WOOD FRAME OBSERVATIONS REPORT

Report Number: 70191114.0018
Service Date: 10/26/20
Report Date: 10/26/20
Task: Structural Steel/Wood

Spout Springs Outparcel
1655 Buffalo Lake Road
Sanford, NC 27332

SHEET TITLE:
ROOF FRAMING PLAN

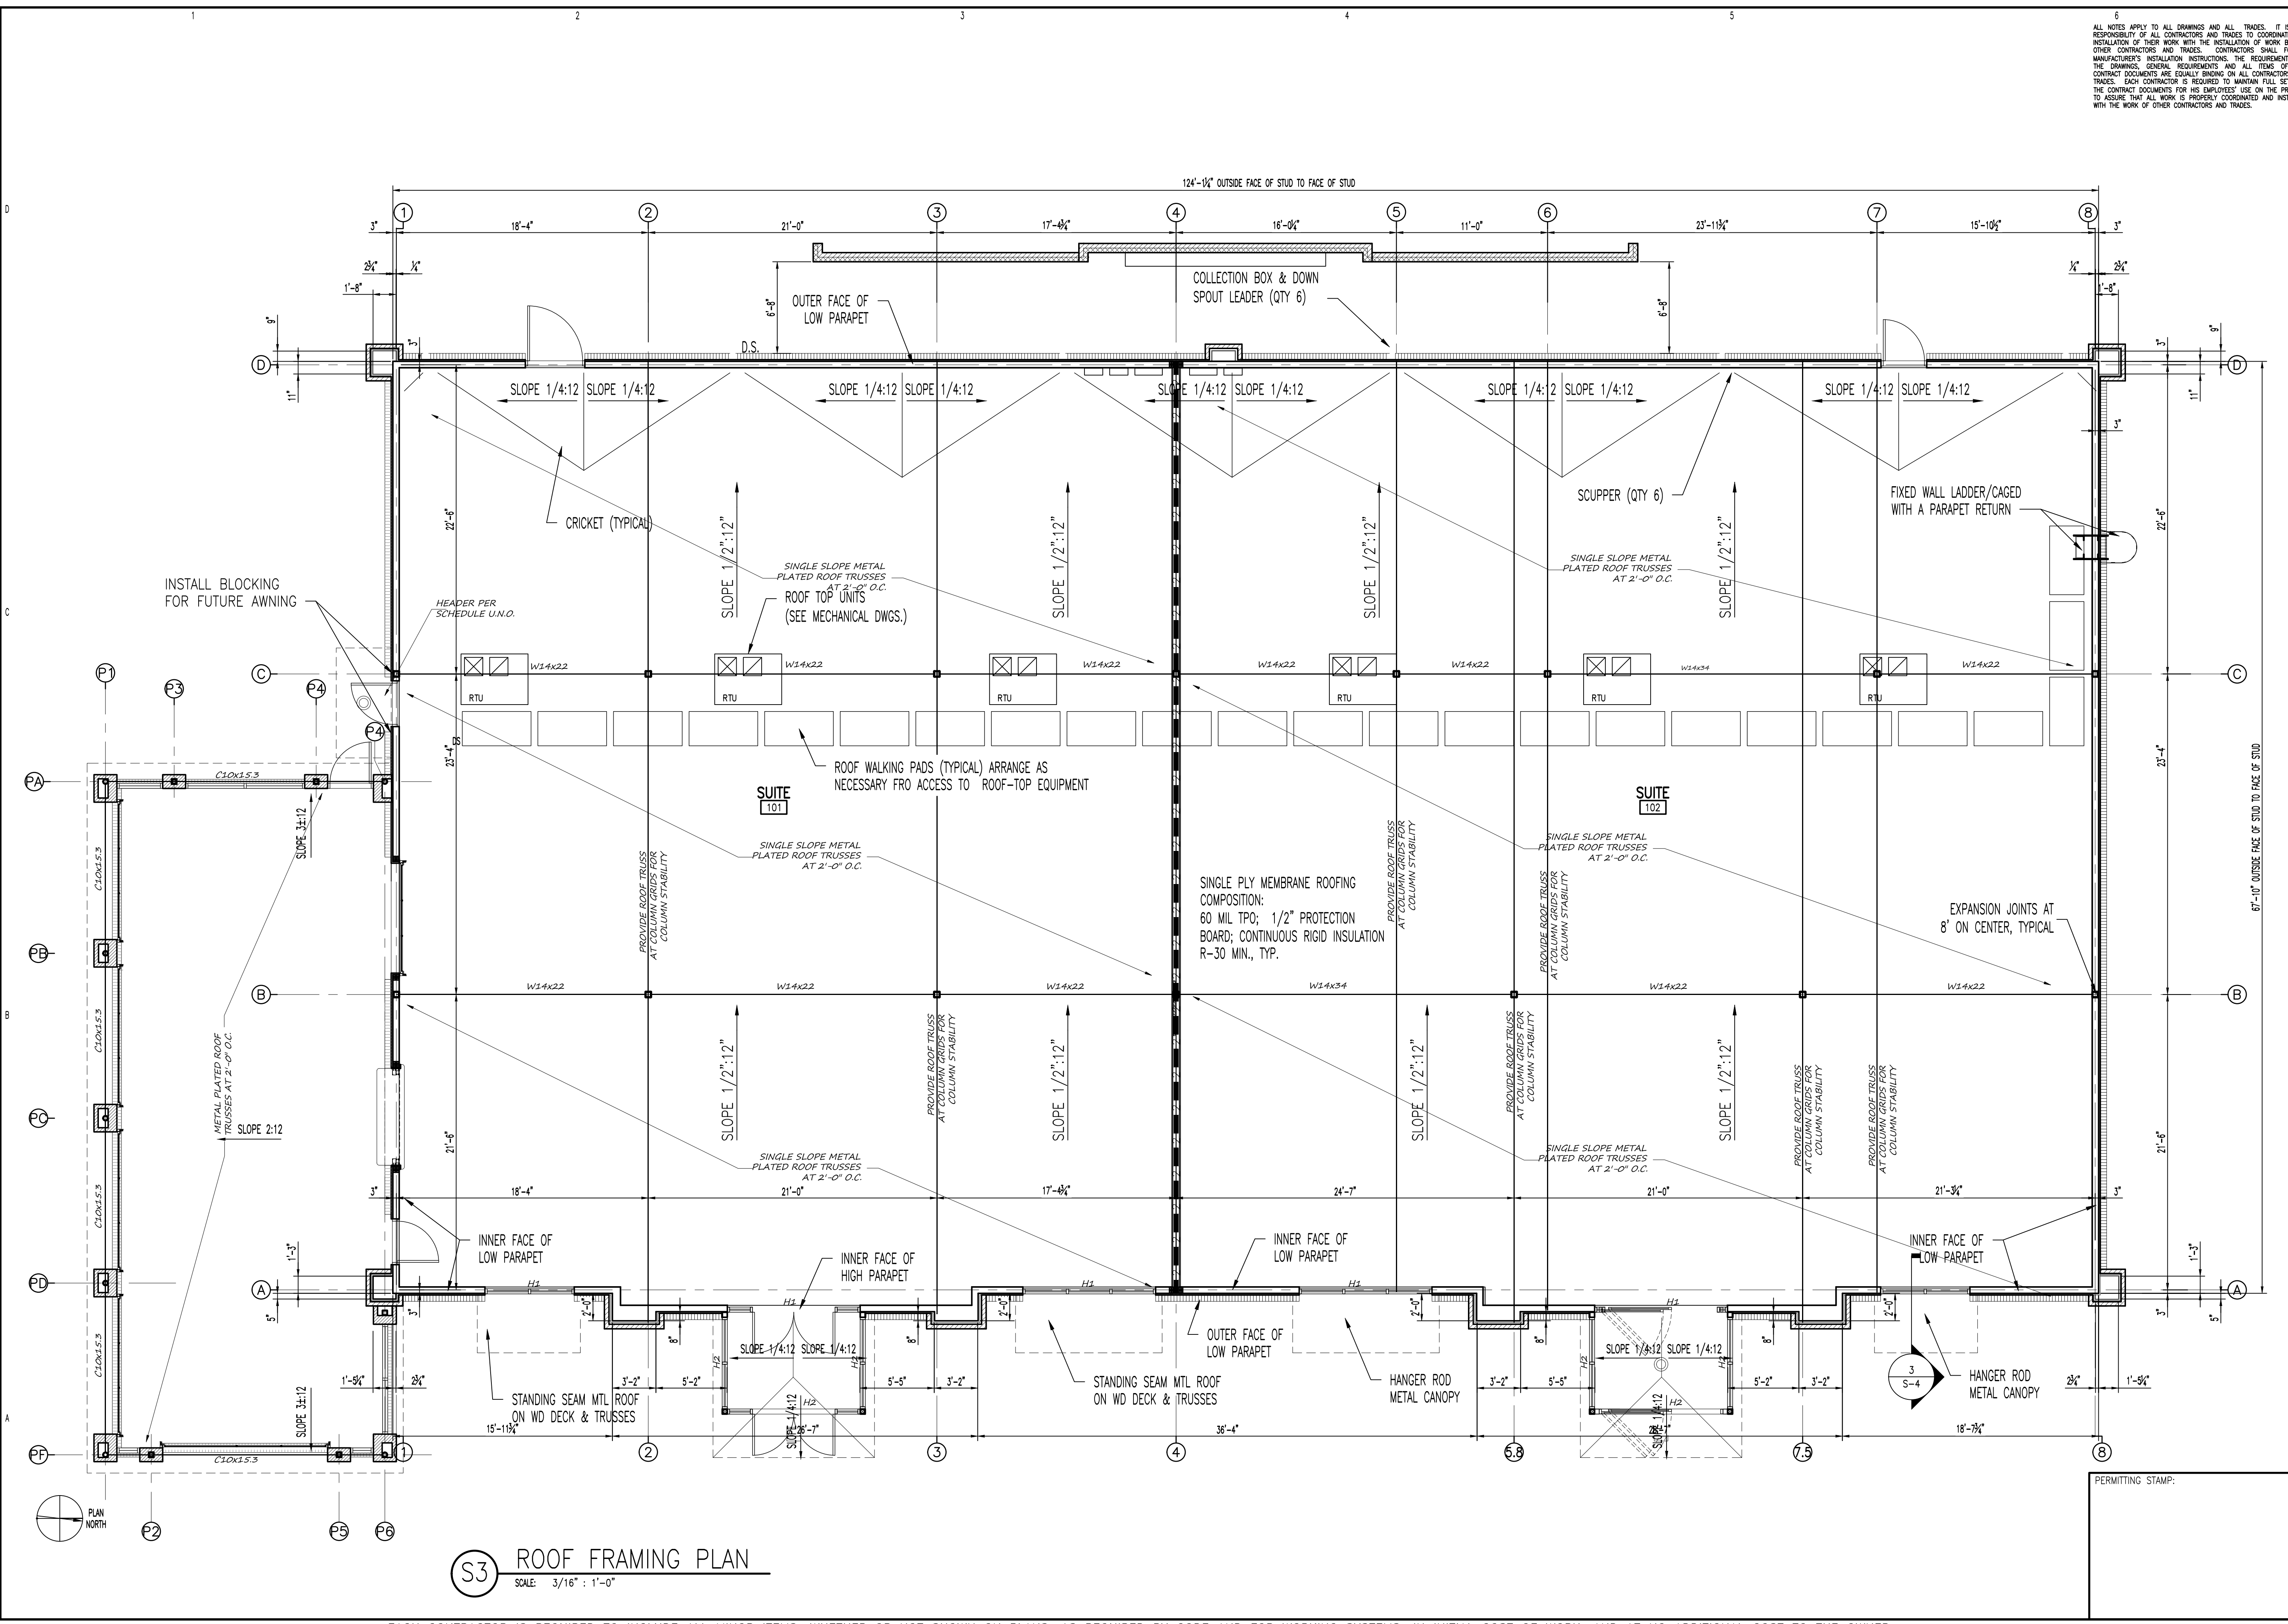
Mexican restaurant outside patio.

- **HUS26 hangers on the eastern and western side for the roof trusses for the exterior patio were missing at the time of inspection.**

All Comments Were Communicated to: David Daughtey with Ray West Design Build. Contractor informed Terracon inspector that all these hangers will be placed by the end of the next business day (Oct. 27, 2020). Next request for observation, request the completed work to be reviewed.
